City of Portland, Maine - Building or Use Permit Application

Permit No: 06-1549	Issue Date:	CBL: 083B F009001
------------------------------	--------------------	-----------------------------

Location of Construction: 83 DIAMOND AVE	Owner Name: BARTLETT NANCY W & NANCY	Owner Address: 11 SAWYER ST	Phone:
Business Name:	Contractor Name:	Contractor Address:	Phone:
Lessee/Buyer's Name	Phone:	Permit Type: Single Family	Zone:

Past Use: Vacant Land	Proposed Use: Single Family Home - New 1200 Sq Ft Single Family Home	Permit Fee: \$1,995.00	Cost of Work: \$190,000.00	CEO District: 1
Proposed Project Description: New 1200 Sq Ft Single Family Home		FIRE DEPT: <input type="checkbox"/> Approved <input type="checkbox"/> Denied	INSPECTION: Use Group Type	
		Signature:	Signature:	
PEDESTRIAN ACTIVITIES DISTRICT (P.A.D.)				
Action <input type="checkbox"/> Approved <input type="checkbox"/> Approved w/Condition <input type="checkbox"/> Denied				
Signature: _____ Date: _____

1 PROPOSED SITE PLAN  
1" = 10'

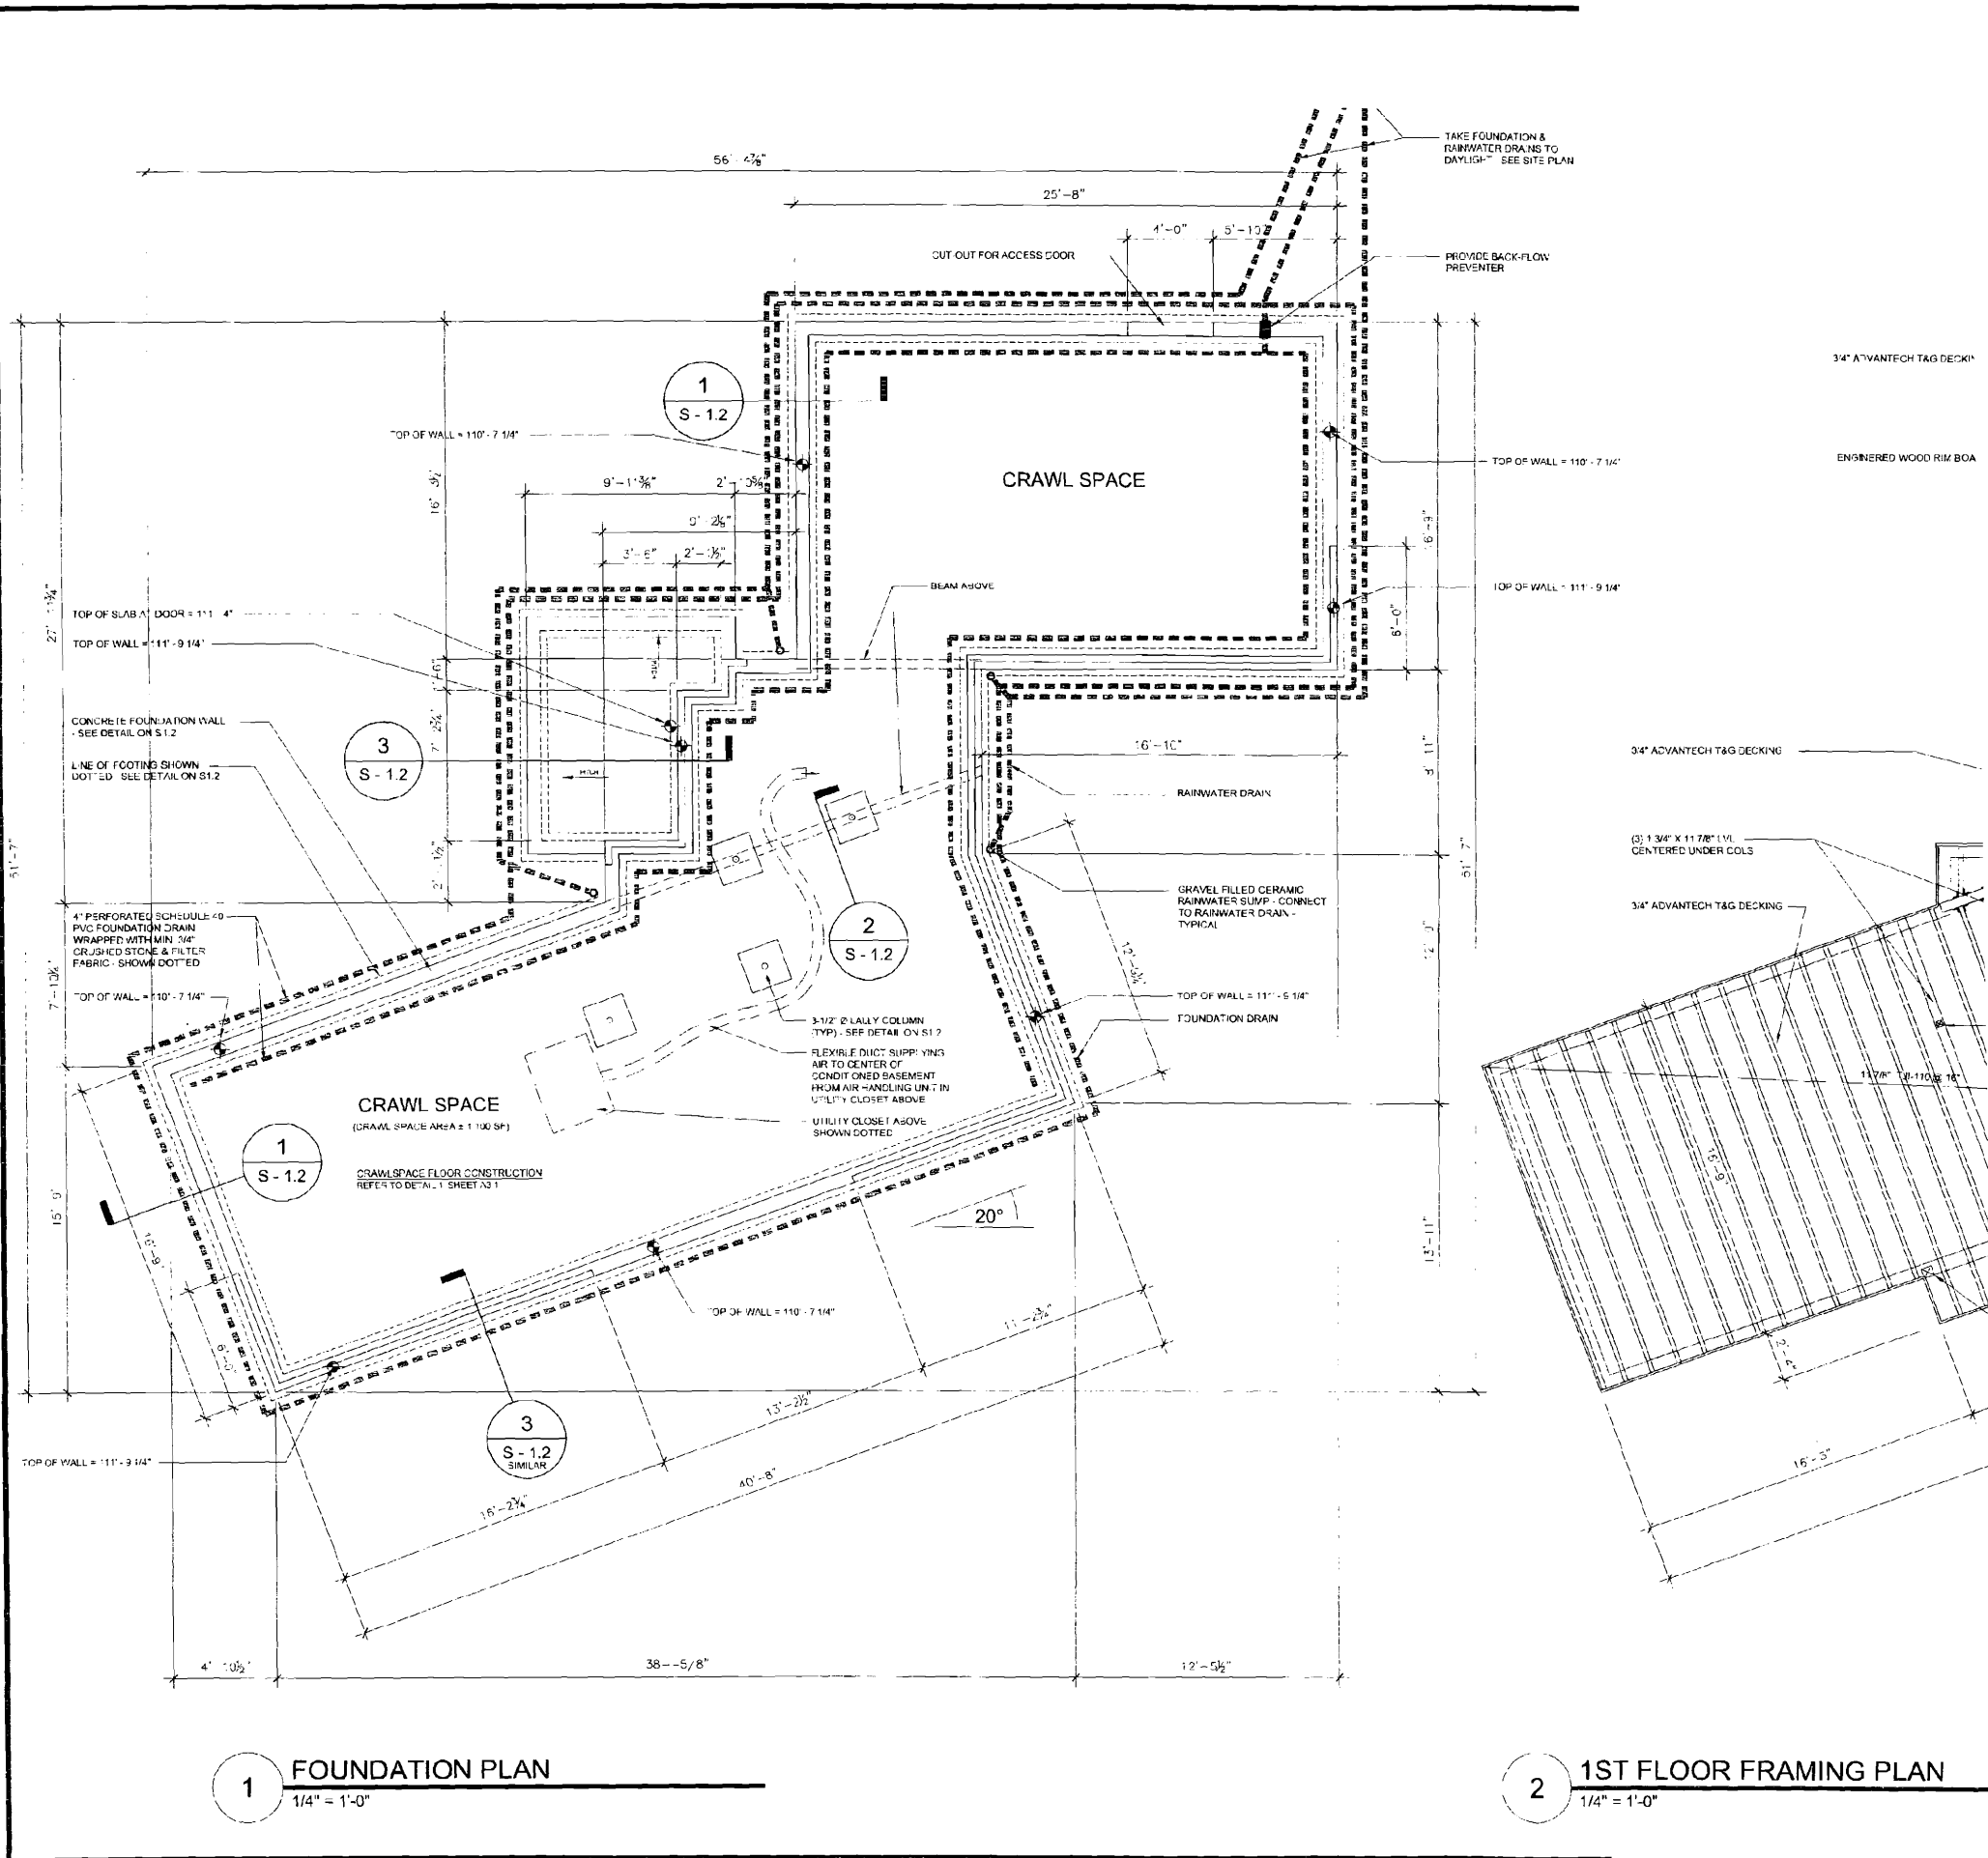
11/20/06. The two parking spaces need to be located passed the front setback & the pre & post construction grade on the elevation plans needs to be more clear. I can't sign off until these are cleared up.

11/20/2006-amachado: Left message with Scott Teas. The two parking spaces need to be located passed the 30' front setback. Pre & post contruction grade on the elevation plans needs to be more clear. I will pass this permit on to the residential plan reviewers in the mean time.

11/20/2006-amachado: Spoke to Richard Lowe, architect. The pre & post construction grades are all set. They still need to address the parking spaces being located beyond the front 30' setback.

3 COVERED PORCH AT FRONT DOOR  
SCALE: 3/4" = 1'-0"

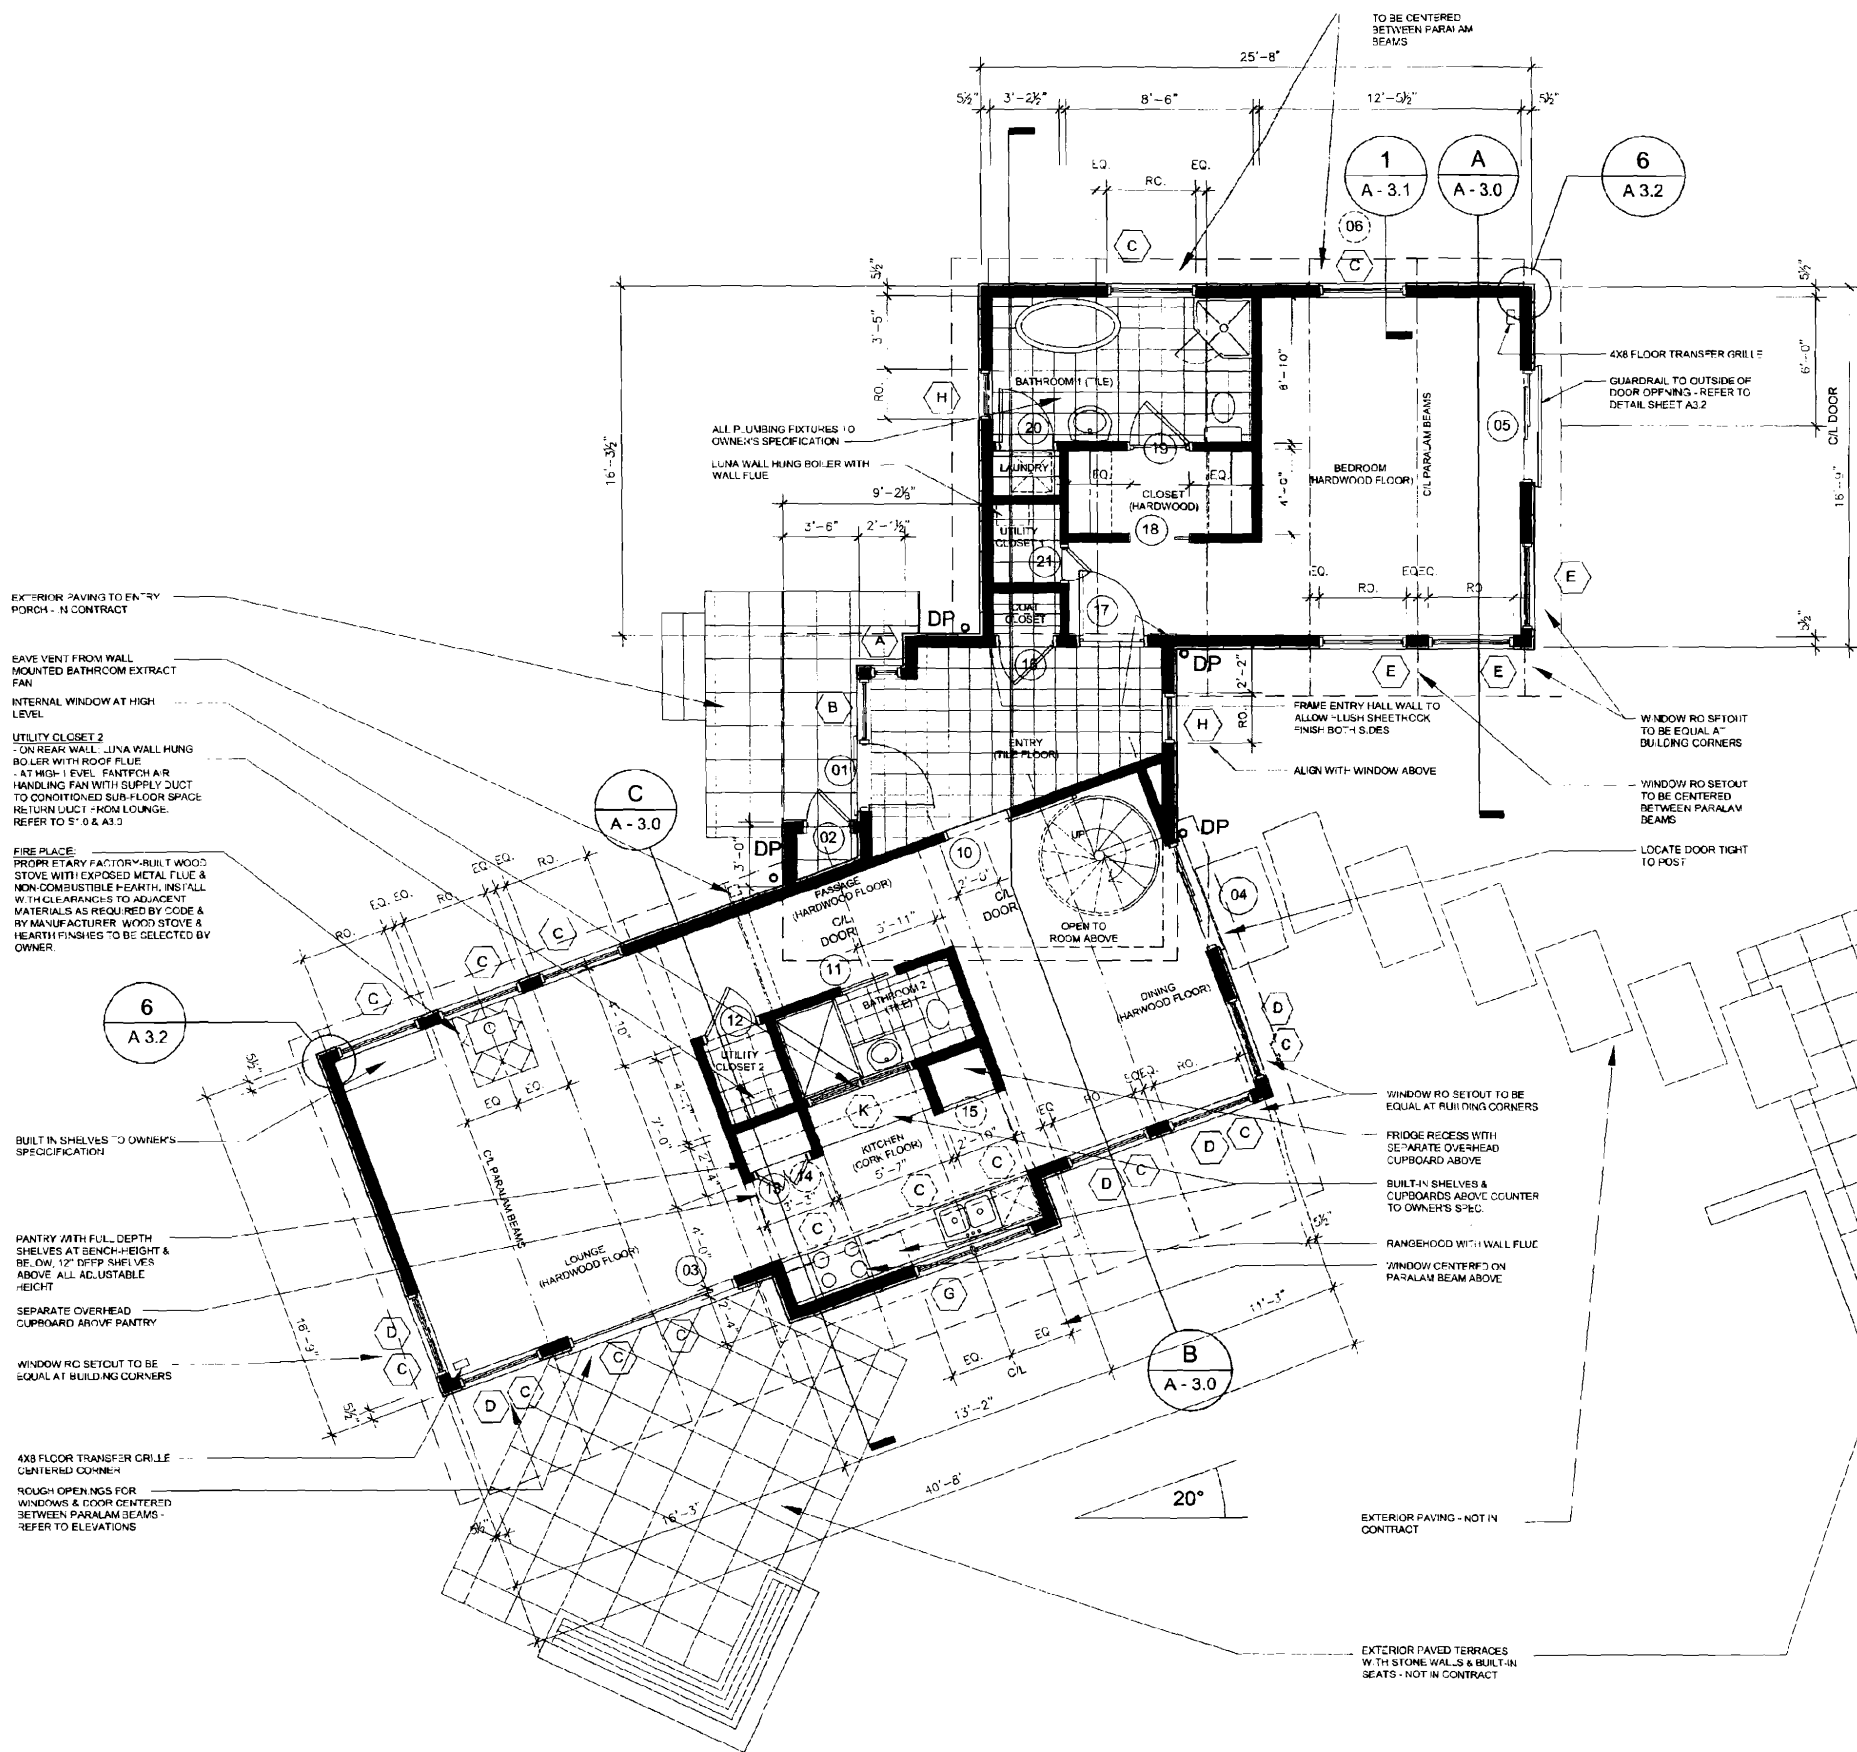
- 4) There must be a 2" clearance maintained between the chimney and any combustible material, with draft stopping per code at each level
- 5) This permit is issued based on the plans submitted. Variations in actual construction that effect grades may change the requirements for handrails and guards.
